KRISTEN ESTATES FINAL PLAT CONSTRUCTION DOCUMENTS

EPC STORMWATER REVIEW COMMENTS
IN ORANGE BOXES WITH BLACK TEXT

KRISTEN ESTATES
EL PASO COUNTY, COLORADO
CONSTRUCTION DOCUMENTS
COVER SHEET

PROPOSED PRIVATE ROAD IMPROVEMENTS - PLAN VIEW

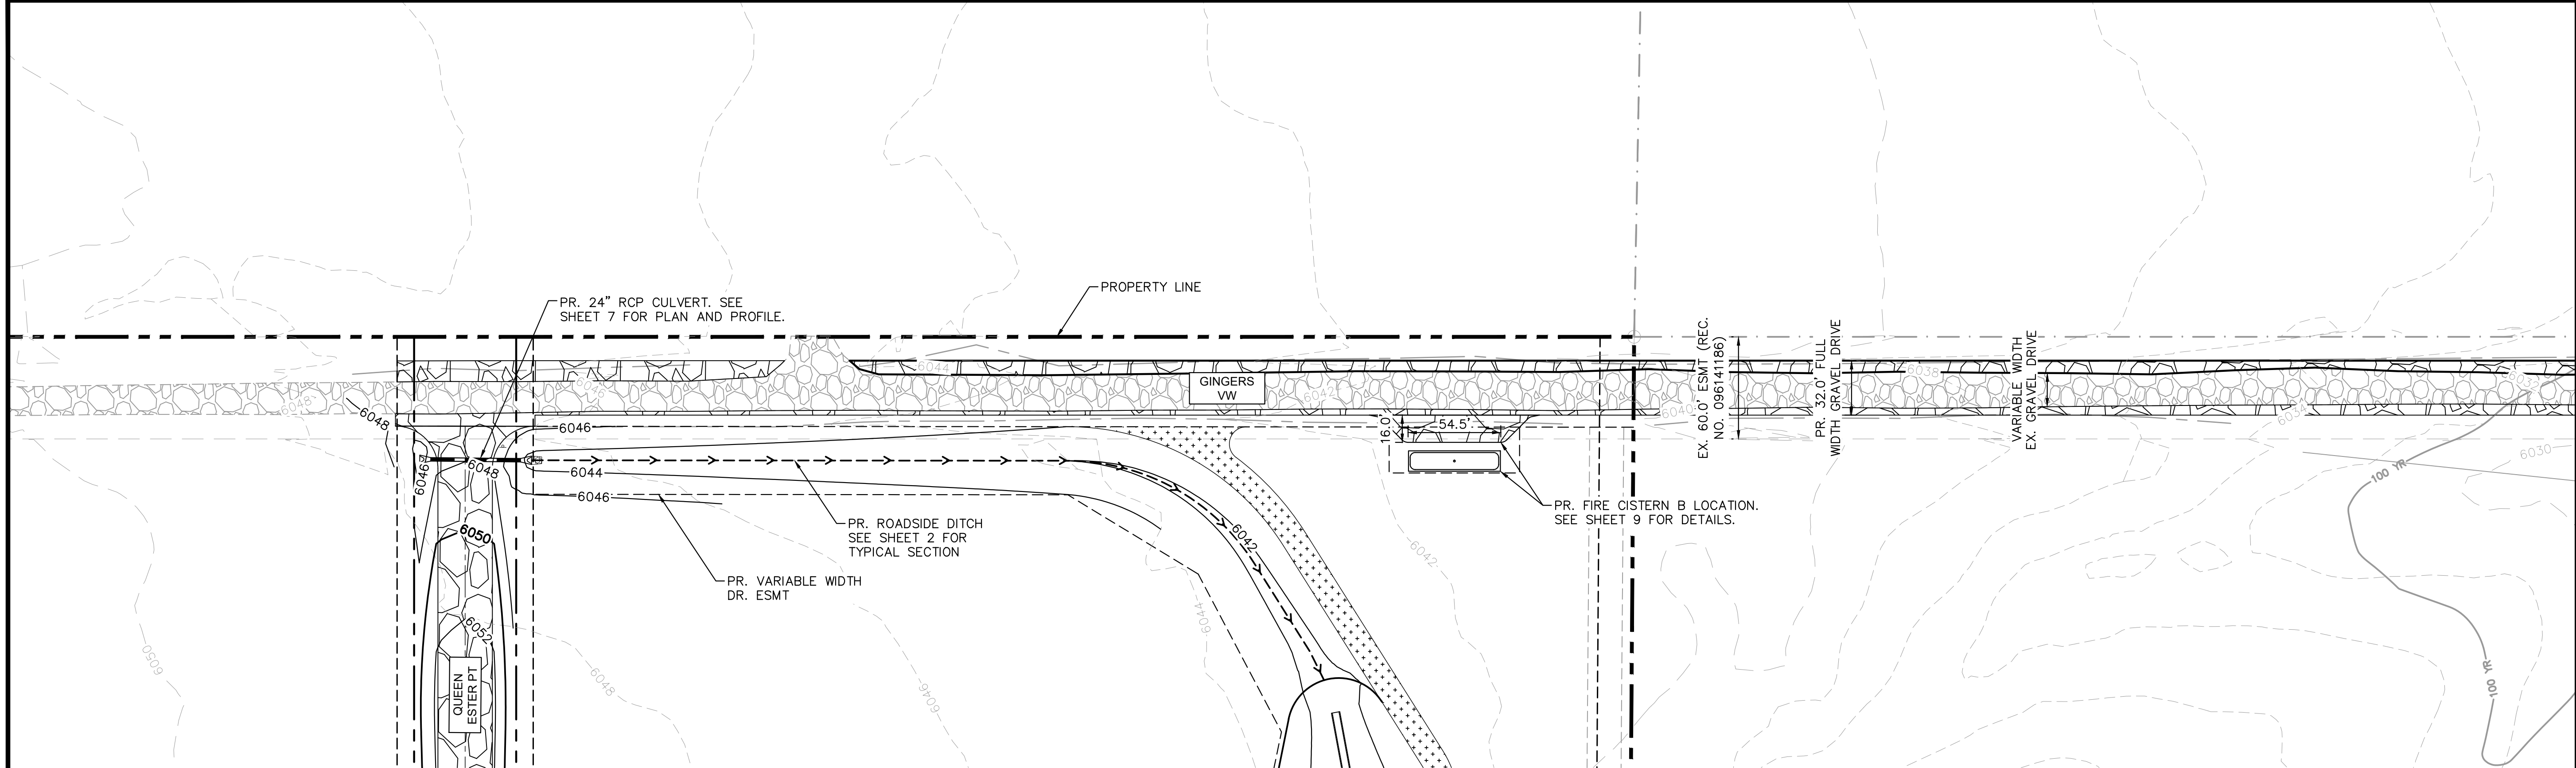
The ECM specifies a maximum of 1,600 feet for a dead end road. A deviation request is required for the length of this roadway added to the north/south roadway.

Ensure all easements are labeled.

Verify that cross section marker title and locations are accurate to detail sheets and update as needed.

KRISTIN ESTATES
EL PASO COUNTY, COLORADO
CONSTRUCTION DOCUMENTS
TYPICAL SECTION & DETAILS

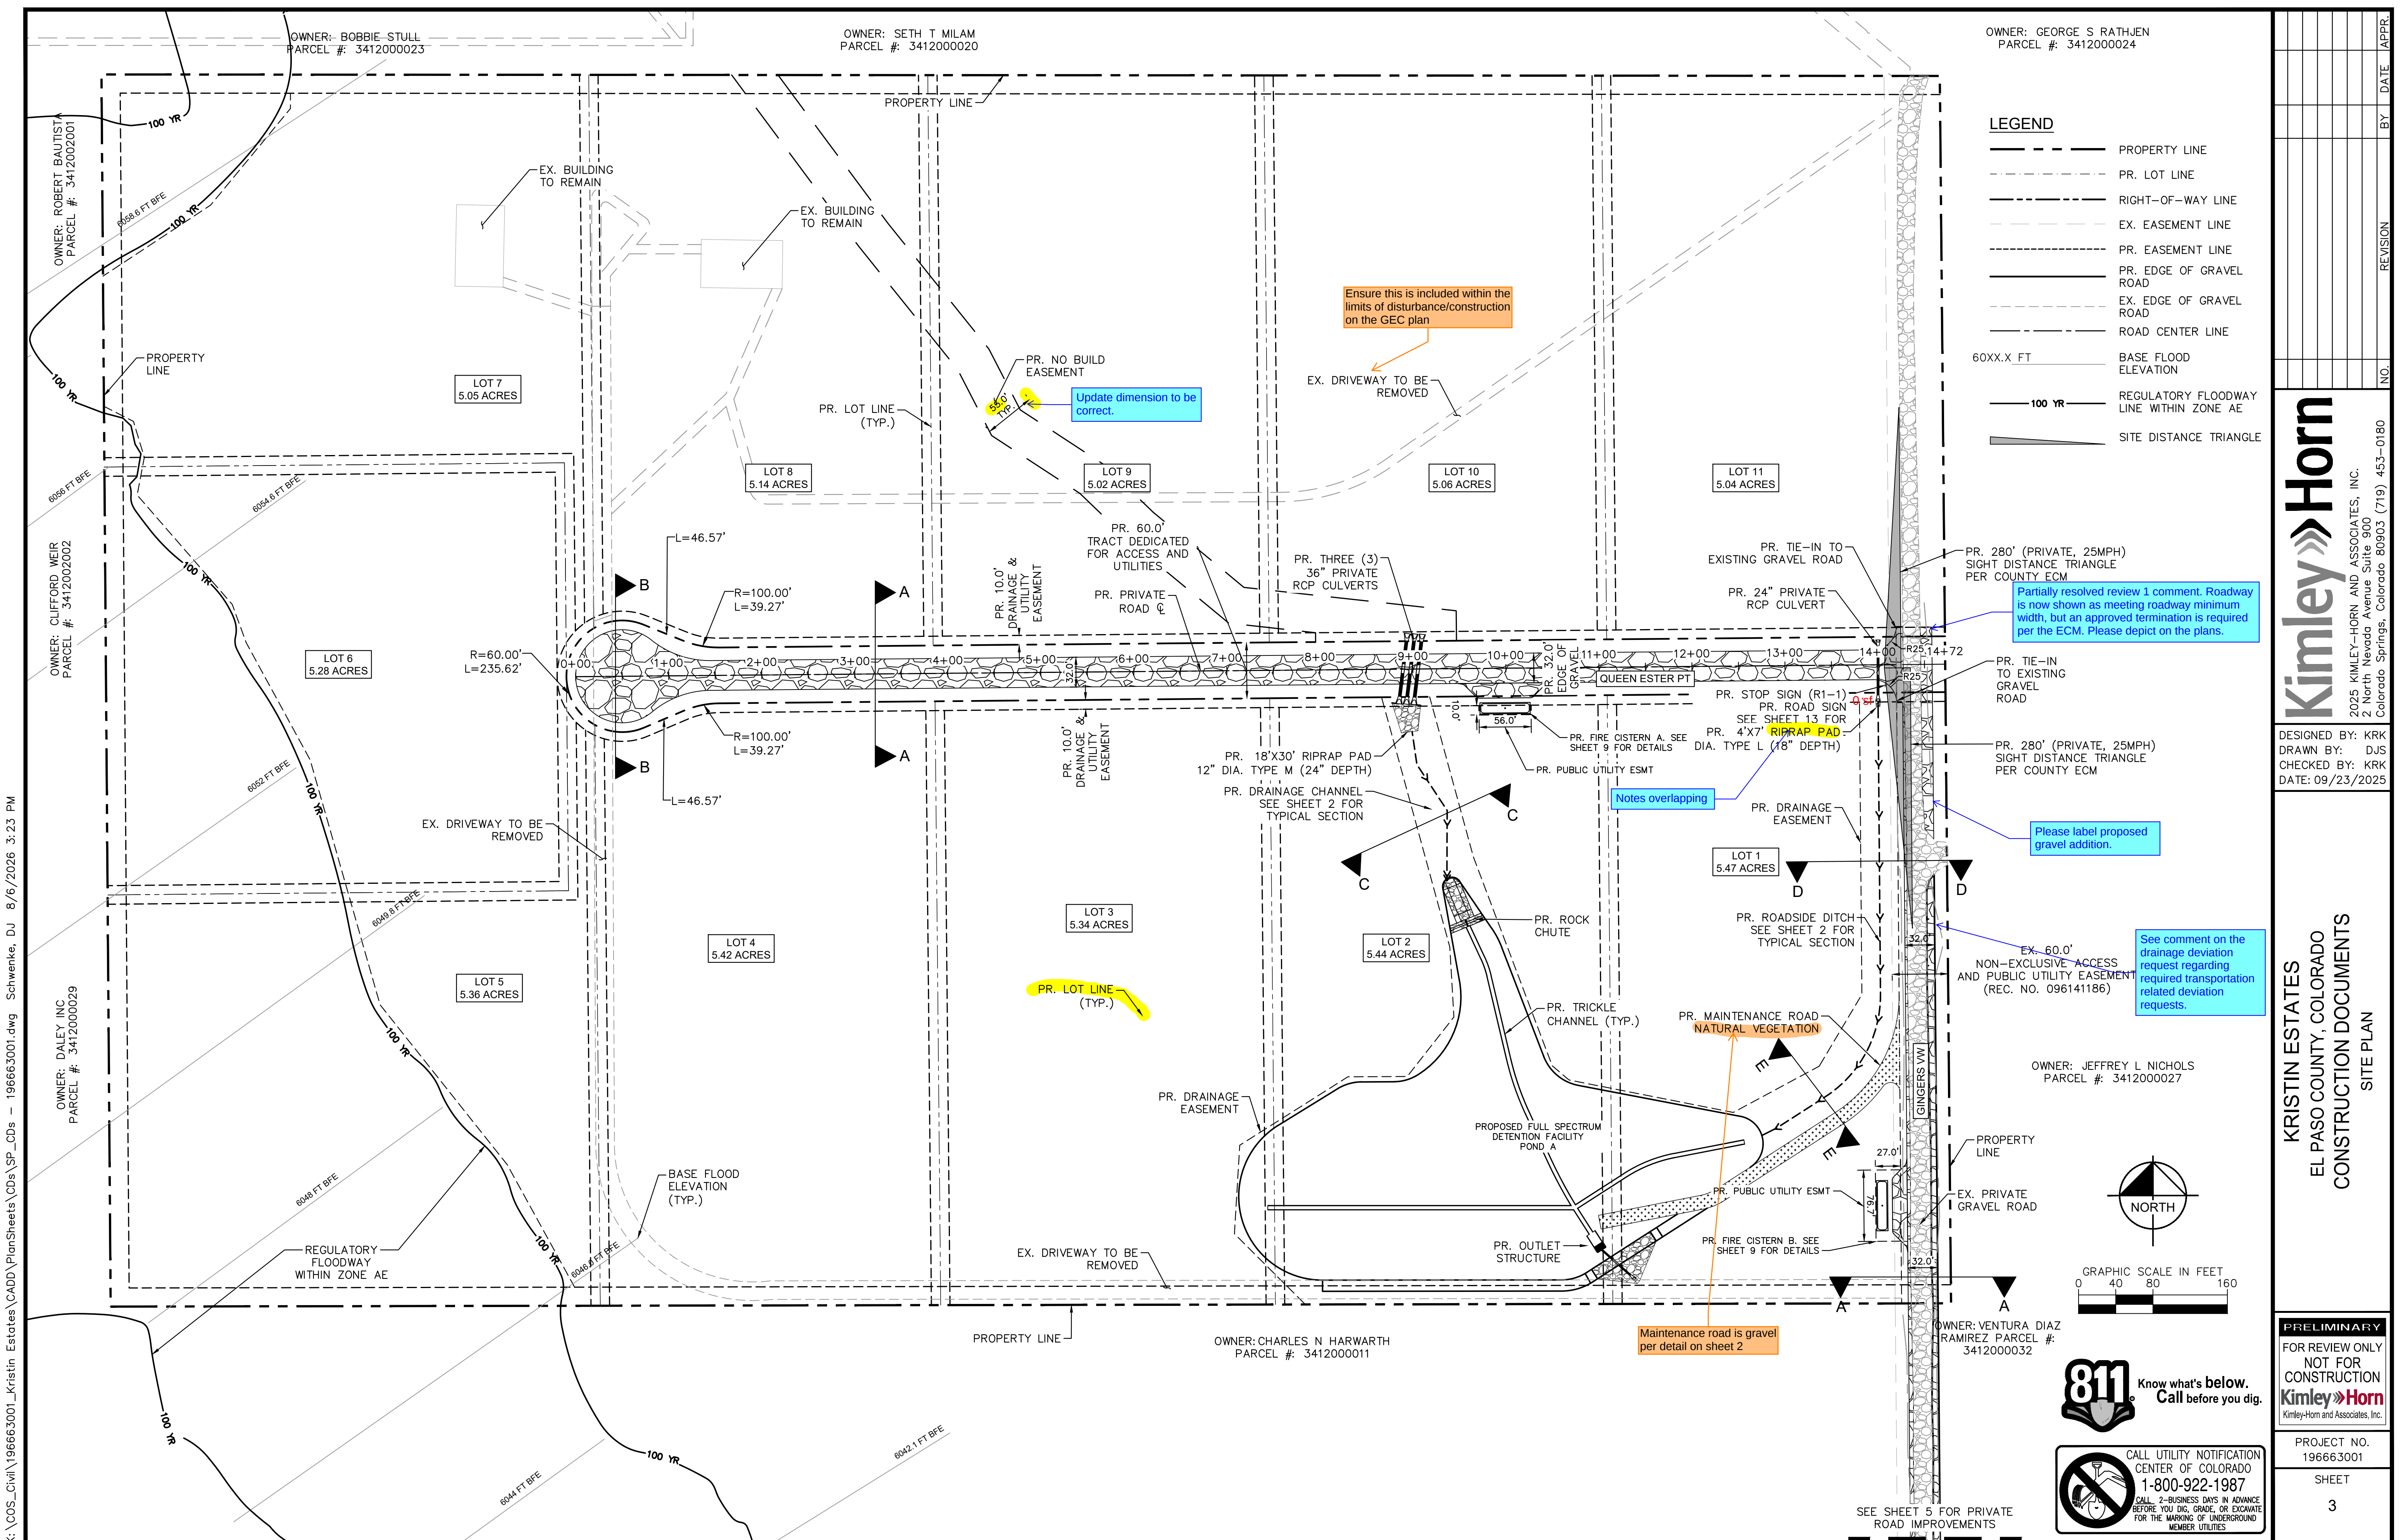
Please label material.
